**re:**     **Geotechnical Review of Site Servicing Plans**  
          **Proposed Residential Development**  
          **5618 Hazeldean Road – Abbott's Run – Block 13 – Ottawa, Ontario**

**file:**   PG7640-MEMO.03

Paterson reviewed the following site servicing drawings set prepared by DSEL for the aforementioned development:

- ☐ Abbott's Run Block 13 Site Plan - Project No. 1295\_Block13, Sheet No. 1 to 19, Revision 2 dated October 24, 2025.

FIGURE 1

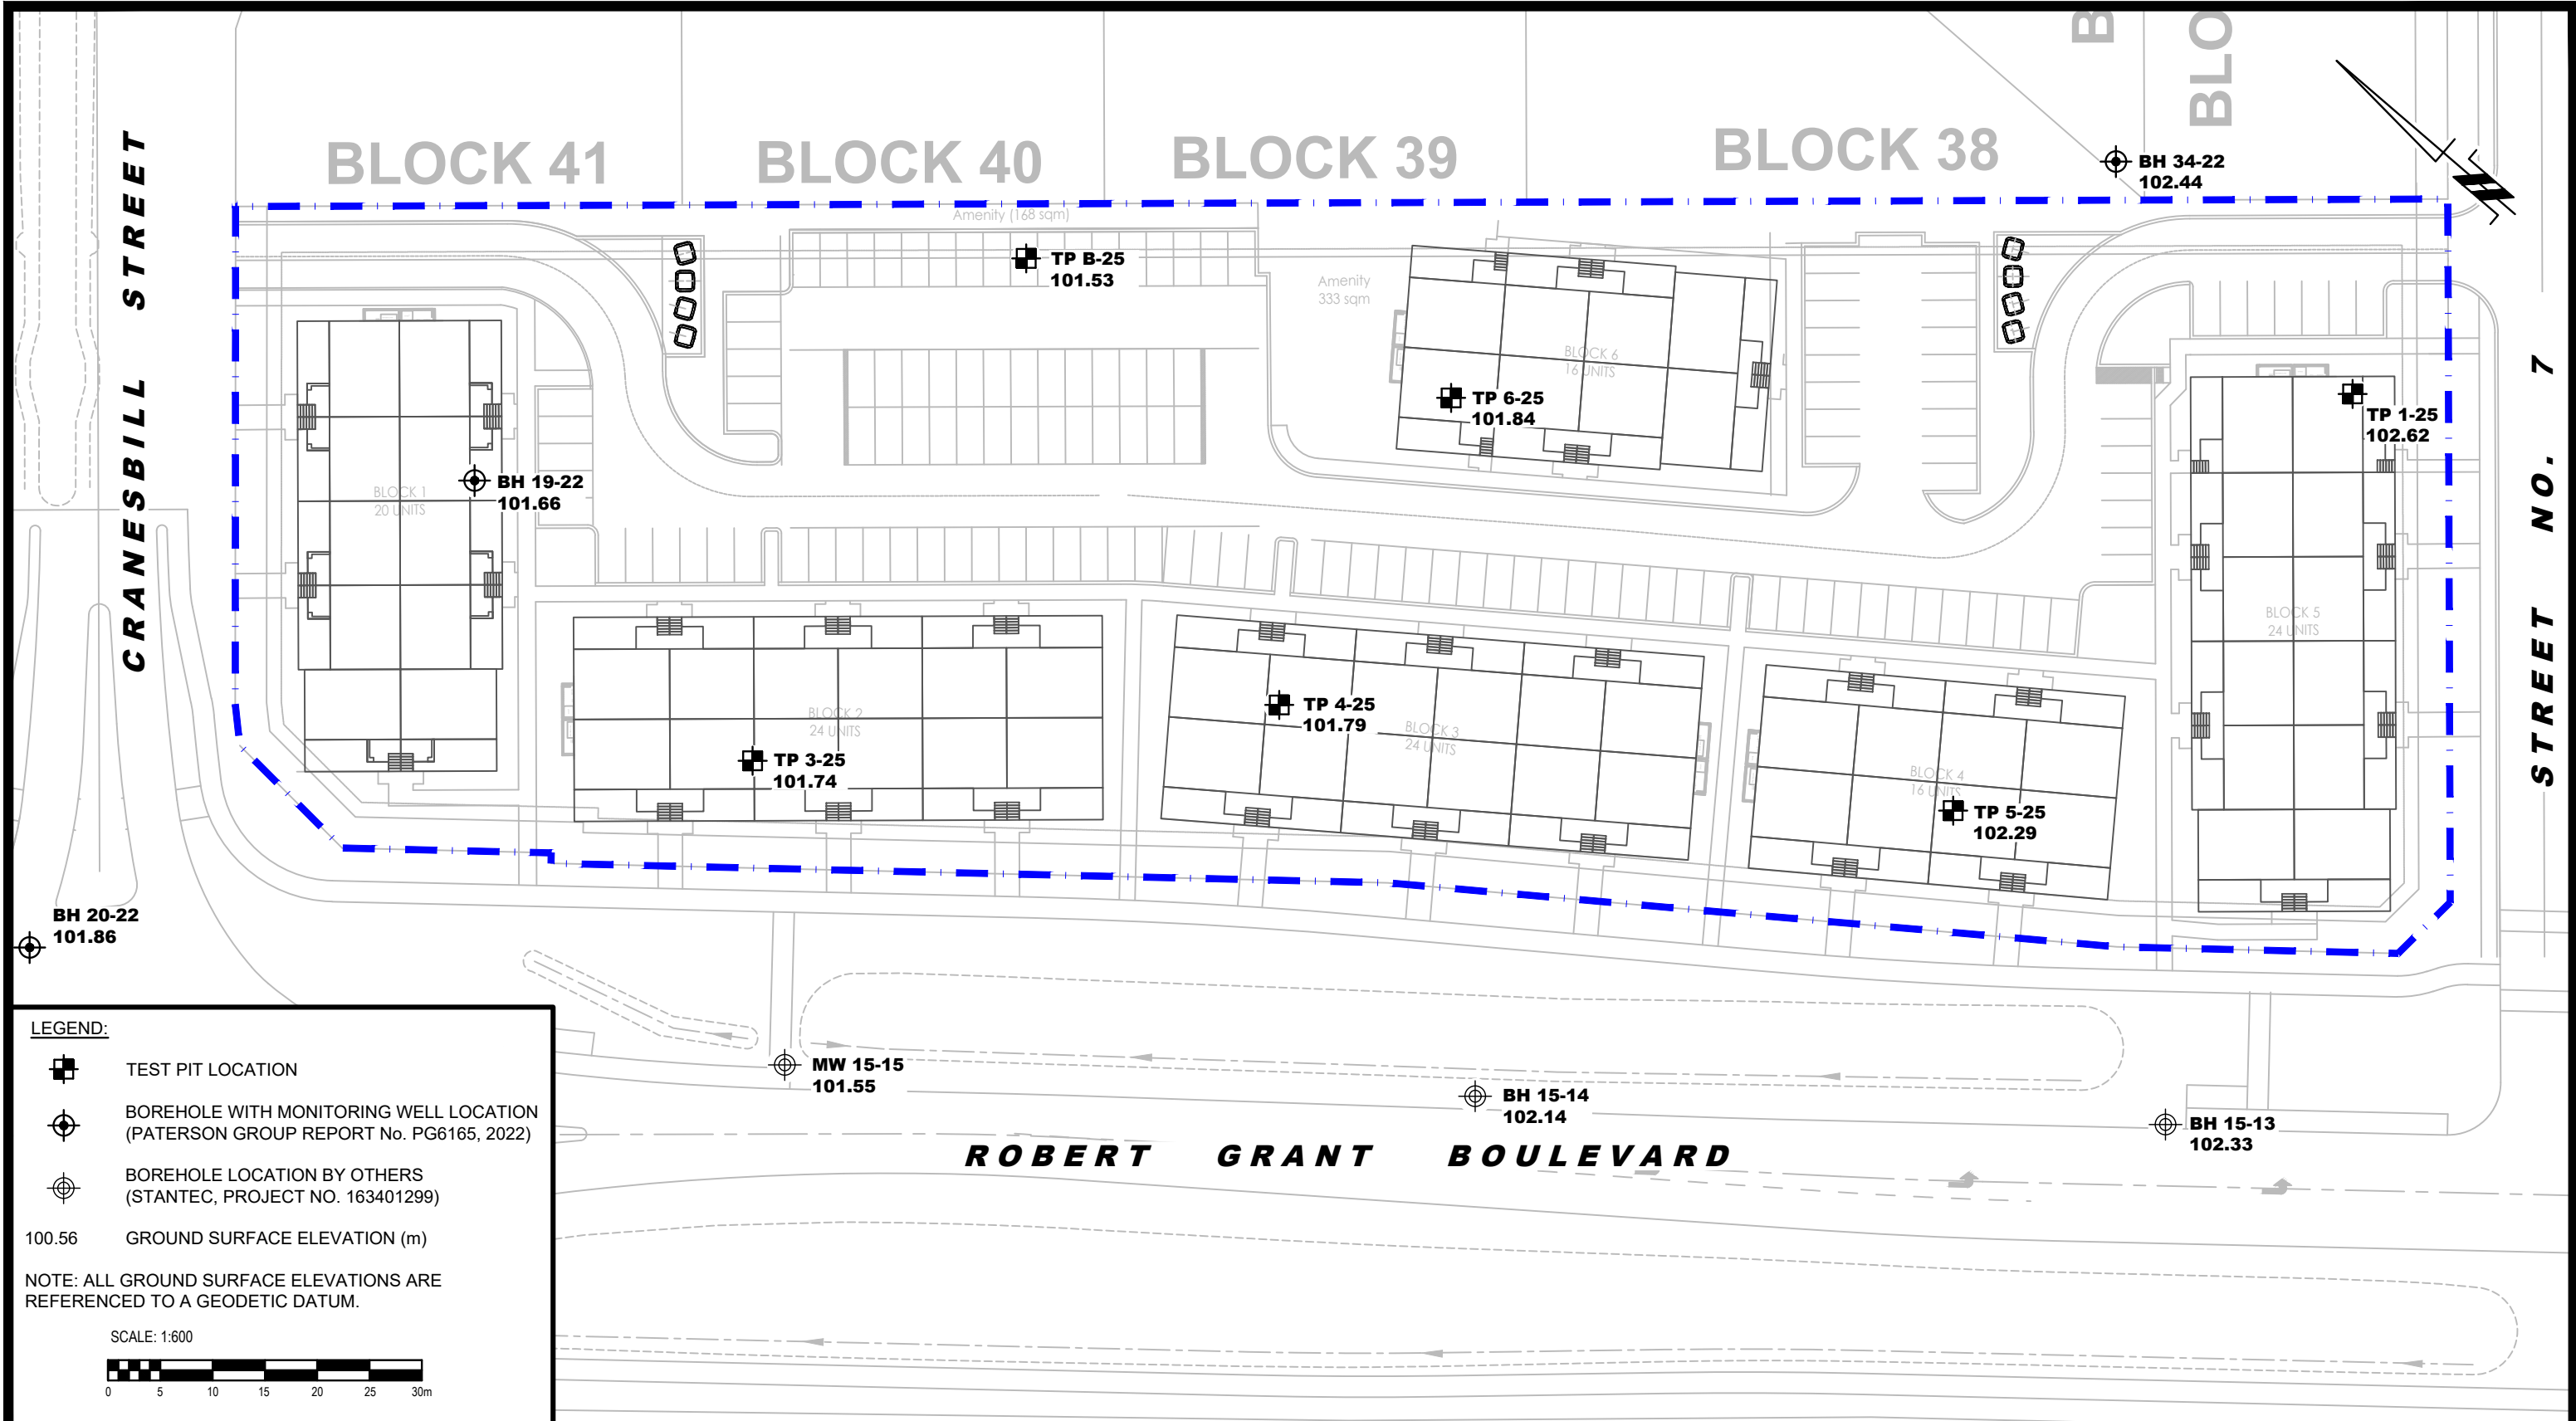
Paterson noted several areas in which underground services are proposed within the lateral zone of influence of the adjacent proposed buildings (i.e. within the plane extending 1 Horizontal:1 Vertical down and outwards from the edge of proposed footing). To ensure that the proposed services do not incur additional loading due to the adjacent proposed dwellings, and to permit future maintenance of the underground services without causing detrimental effects to the adjacent structures, Paterson has provided additional construction recommendations in subsequent sections of the present memorandum

It is recommended that the lateral zones of influence be lowered in the affected areas such that the influence plane (1H:1V) extending down and outwards from the edge of the proposed footings do not contain any underground services. This may be accomplished by extending the underside of footing (USF) for impacted strip footings to the elevations provided in Table 1 below. Alternatively, this may be accomplished by casting a near-vertical lean-concrete (minimum 15 MPa, 28-day strength) in-filled trench extending between the design underside of footing elevation to the recommended elevations provided below in Table 1 to a depth which would be unaffected by service trench works. The near vertical, zero-entry trench should extend horizontally a minimum 150 mm beyond the overlying footing faces.

| Table 1 – Design Recommendations for Lateral Support Zone Interferences                     |                           |                                                              |                               |
| Block / Lot Number                                                                          | Current USF Elevation (m) | Revised USF/ Underside of Lean-Concrete Trench Elevation (m) | USF Concrete Trench Depth (m) |
| Block 1 – Unit 1 & 2 Staircase Footing                                                      | 101.51*                   | 100.31                                                       | 1.20                          |
| Block 1 – Unit 3 & 4 Staircase Footing                                                      | 101.51*                   | 100.31                                                       | 1.20                          |
| Block 1 – Unit 7 & 8 Staircase Footing                                                      | 101.51*                   | 100.61                                                       | 0.90                          |
| Block 5 – Unit 4 & 5 Staircase Footing                                                      | 102.01*                   | 100.11                                                       | 0.90                          |

The extents of the trench running below a strip footing and adjacent to a site service pipe should be terminated by extending the trench upwards and back up to the design underside of footing elevation at an incline of 1H:2V along the opposite oriented-running strip footings. Reference should be made to the attached Figure 1 – Recommended Lateral Zone of Influence Protection Areas for approximate locations in which the above-noted recommendations should be carried out.
